Re: 356 State St., BP# 2016-00971 plan review comments - jmb@portlandmaine.gov

Subject: Re: 356 State St., BP# 2016-00971 plan review comments

Hi Erin, Thank you for the revised plans dated 5/6/16, this is much more in line with the details discussed with Deen at our preliminary meeting in April. From this, I have one additional comment: 1. The UPC 2009 plumbing code requires wash sinks, including 3 bay and hand wash sinks to be plumbed directly to the drainage system, see Sec. 704.3, and also have a floor drain adjacent to these. The plumbing details shows these fixtures draining to an indirect waste line. Please address this detail. Let me know if you have any questions. Thanks, Jeanie

SHEET NUMBER:
QF200

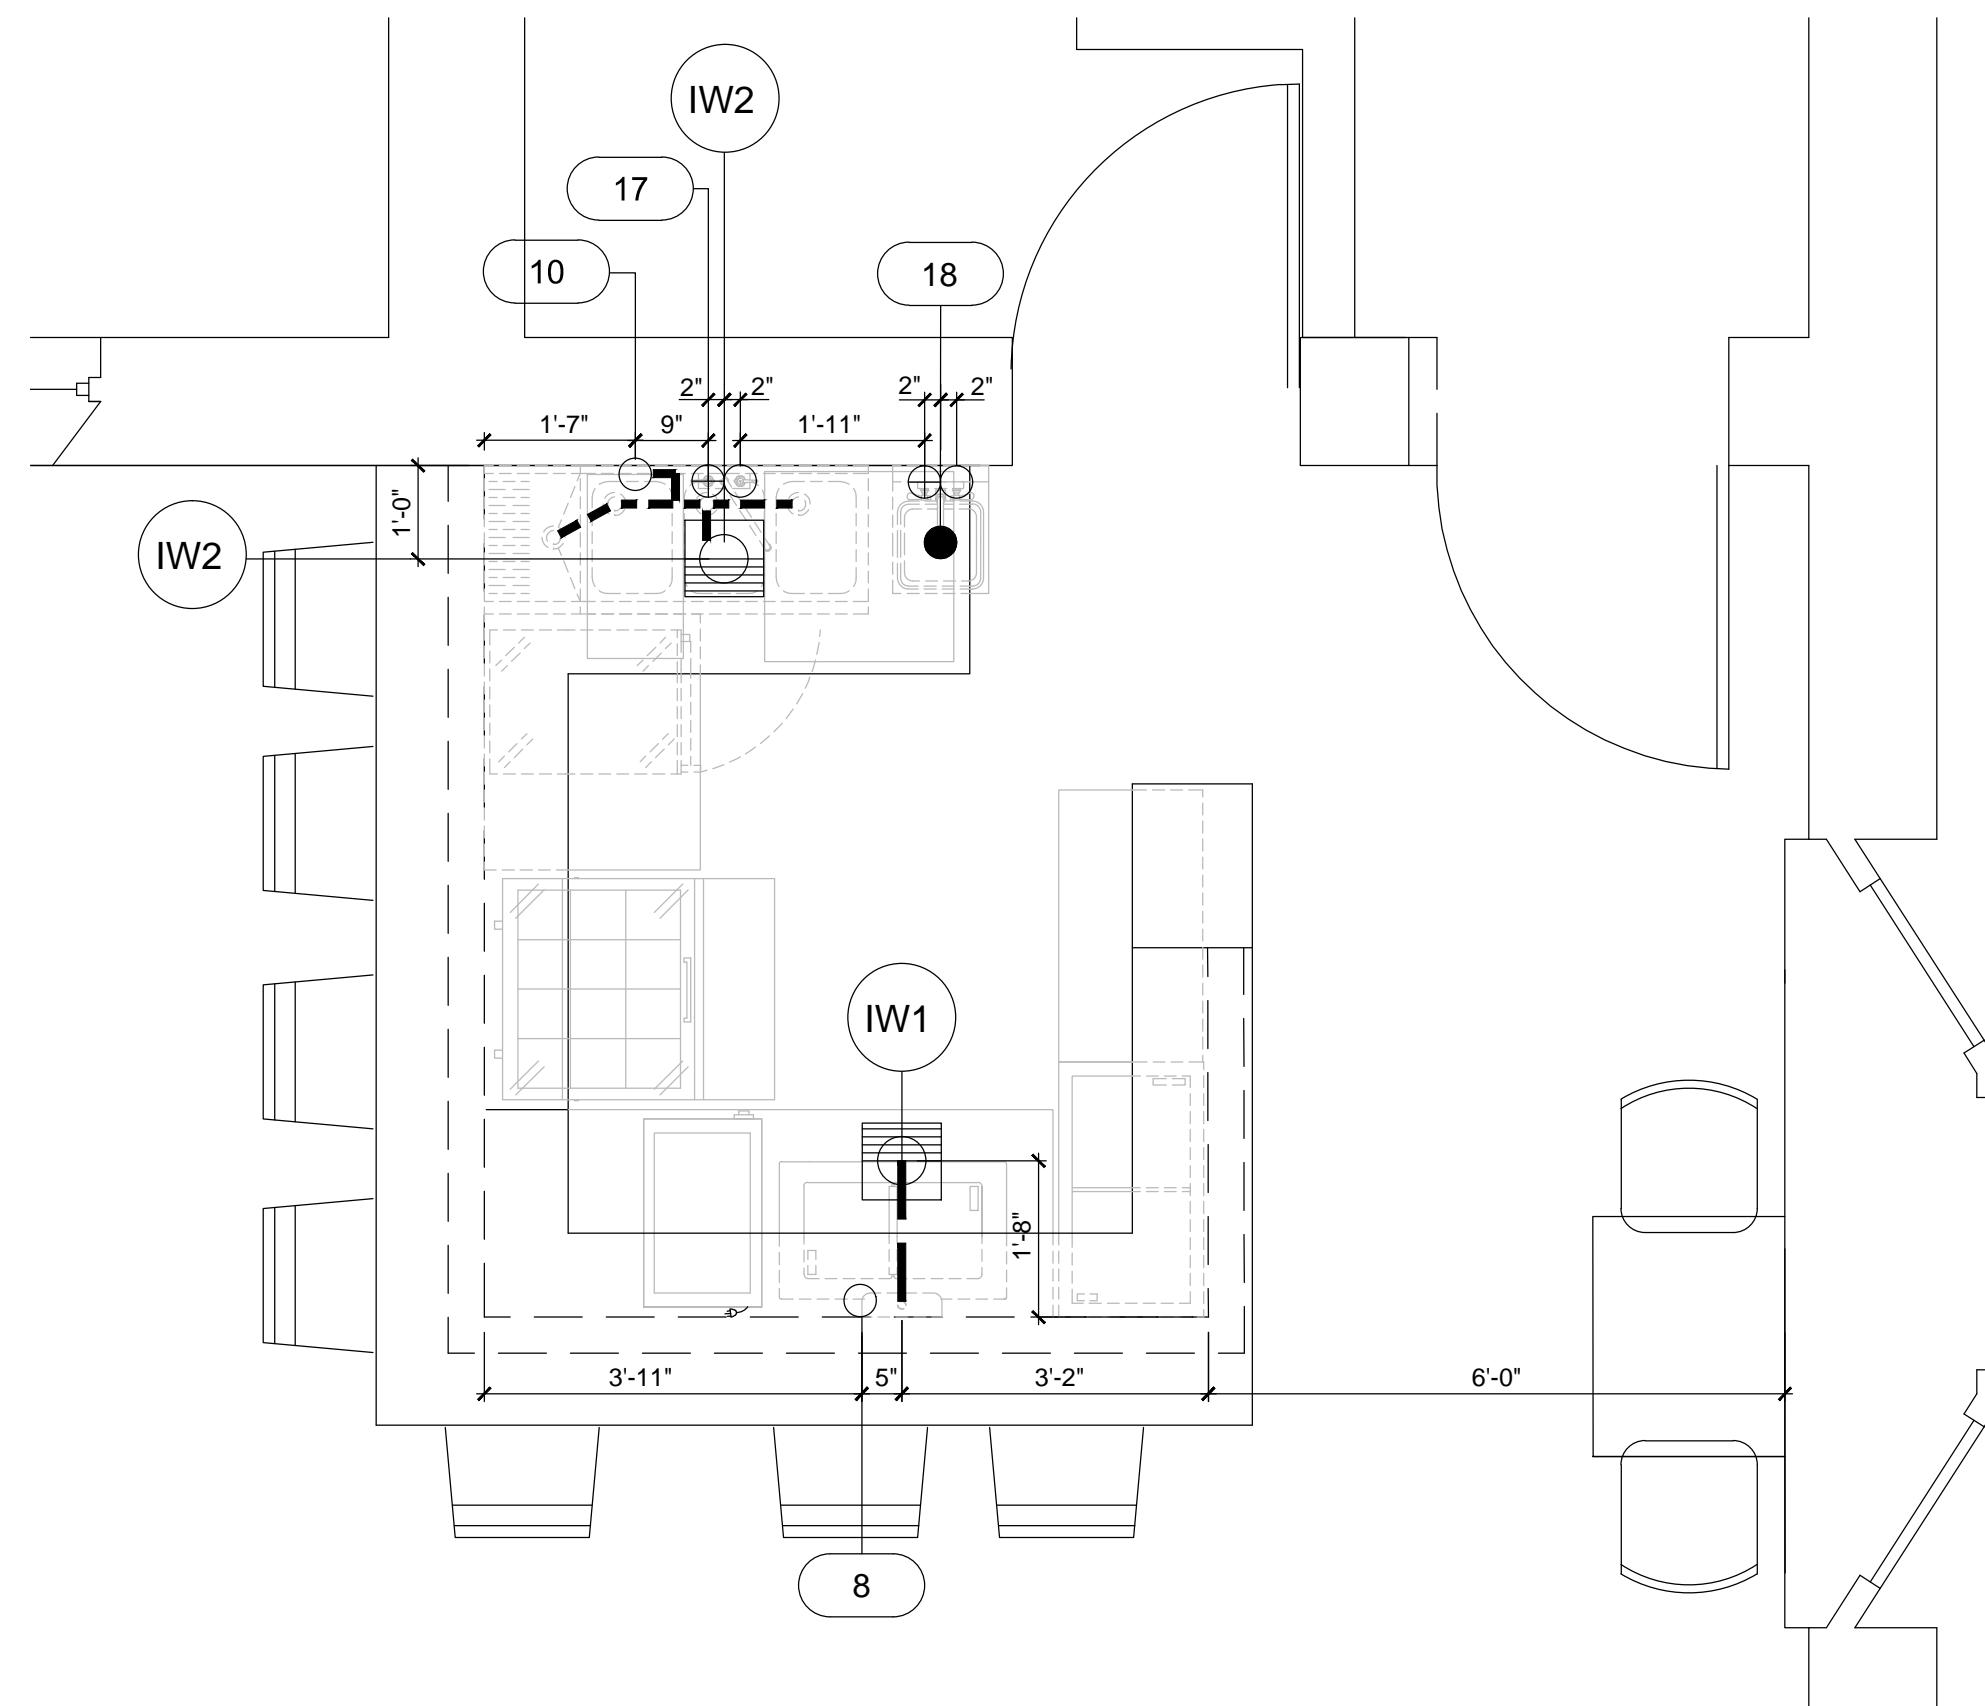
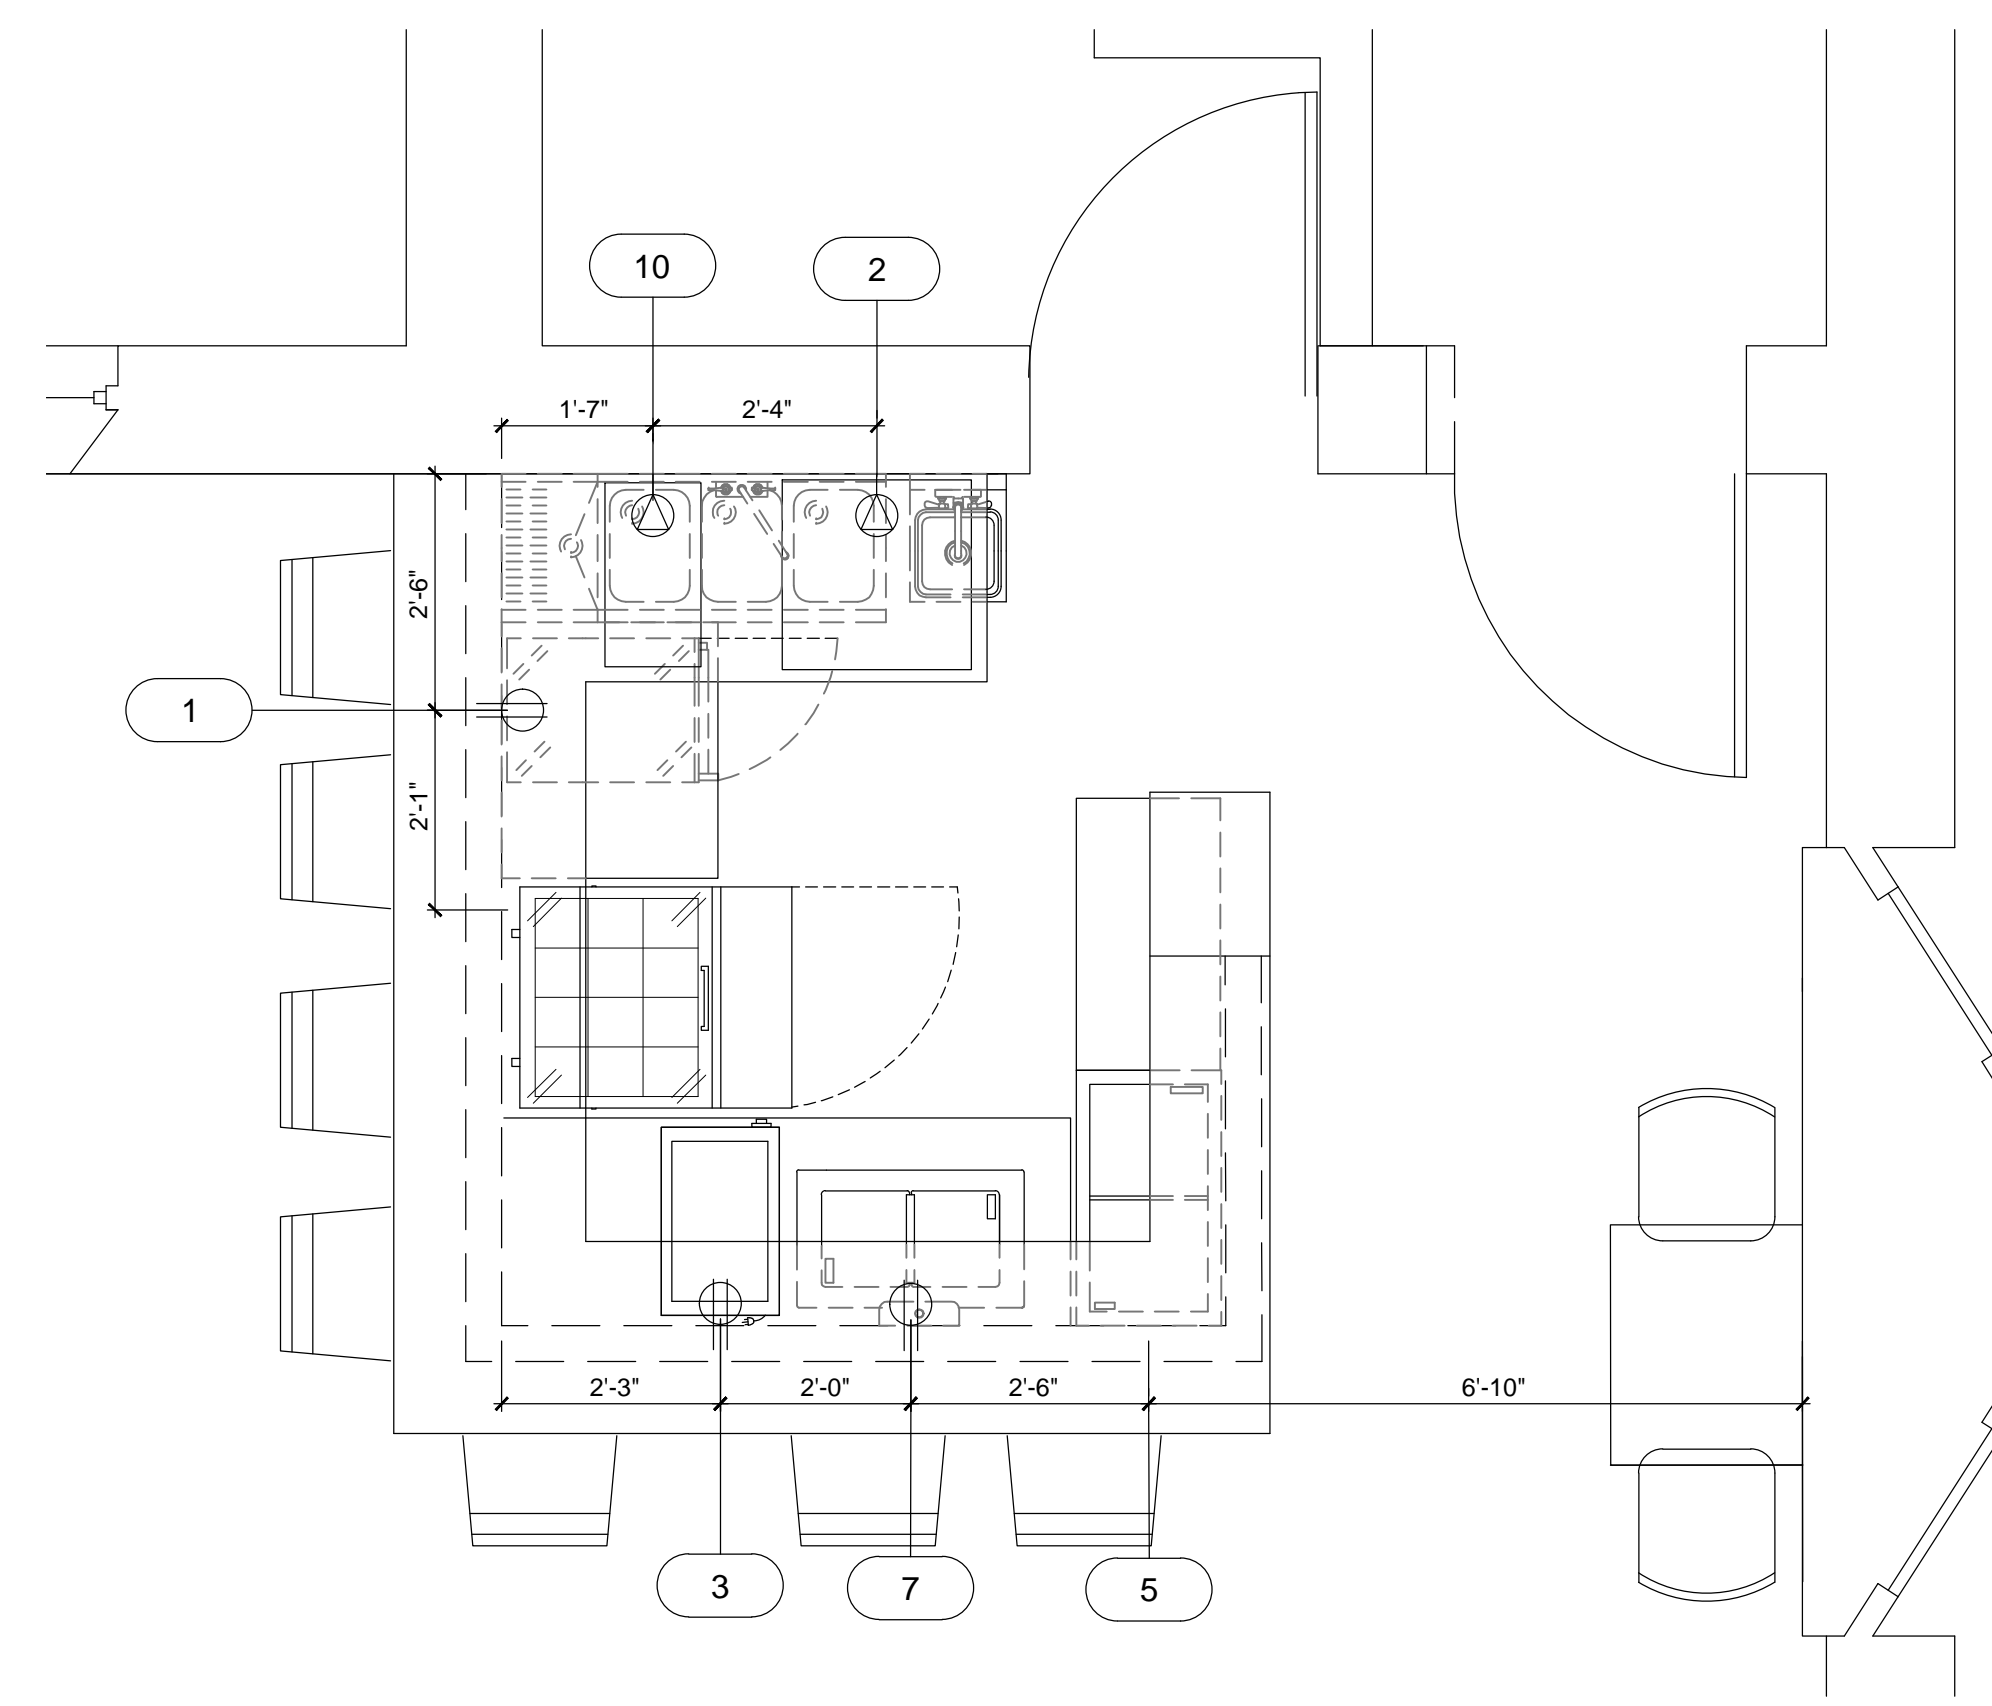
Thank you for this information. To summarize, and in lieu of revising the plumbing plans, your email confirms, that contrary to the plumbing plan and schedule designed by TriMark, there will be no floor drains or floor sink drains installed. All fixtures will either be hard piped directly to the drainage waste system or indirectly with an air gap to an above slab receptacle.

That's correct and sorry for the confusion (we forgot to tell TriMark about the radiant heat).

Hi Jeanie, Please see attached email from Rachel and use these emails to update your records. In short, there will not be a floor drain at the castle. We will be using one of the grease traps recommended by the city and have it maintained consistent with the instructions provided. Please let me know if you have any additional questions. Sincerely, Deen

FOODSERVICE EQUIPMENT LAYOUT
SCALE: 1/4" = 1'-0"

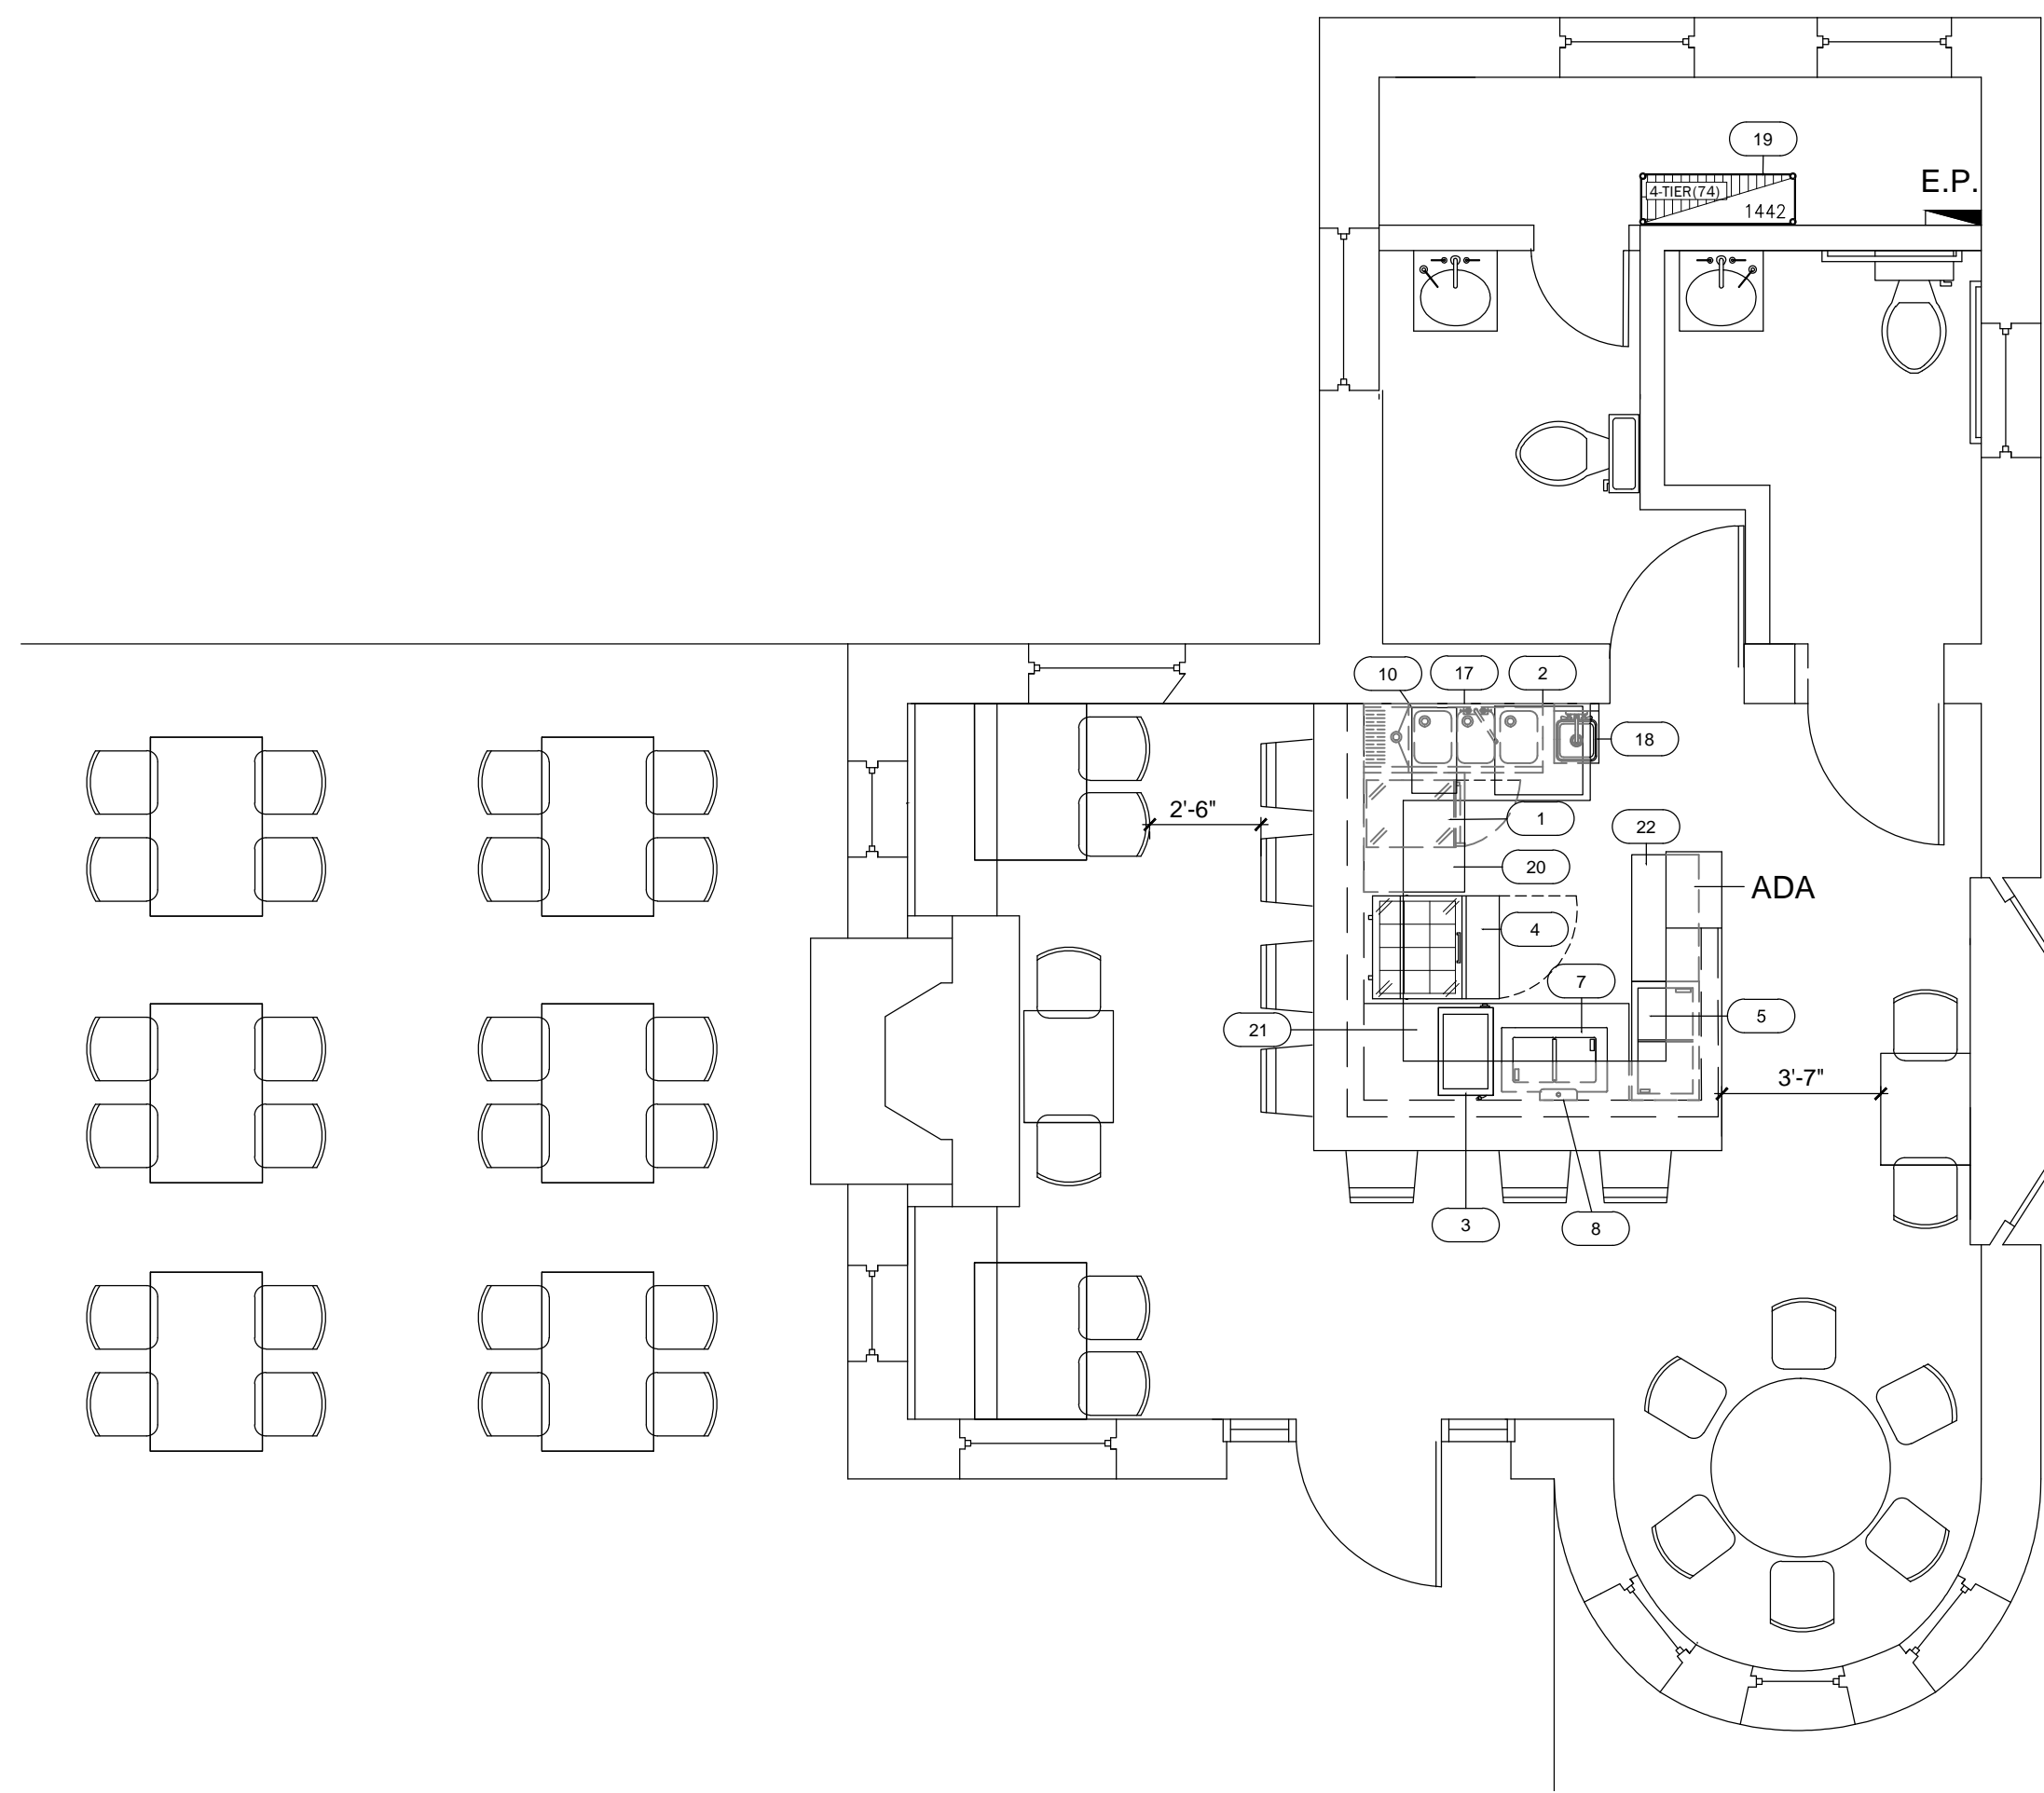
In addition to this information, please confirm the height of the tables for compliance with the 5% seats dispersed per ADA.

The tables will 30" high. They are exactly the same as the ones used in our current restaurant.
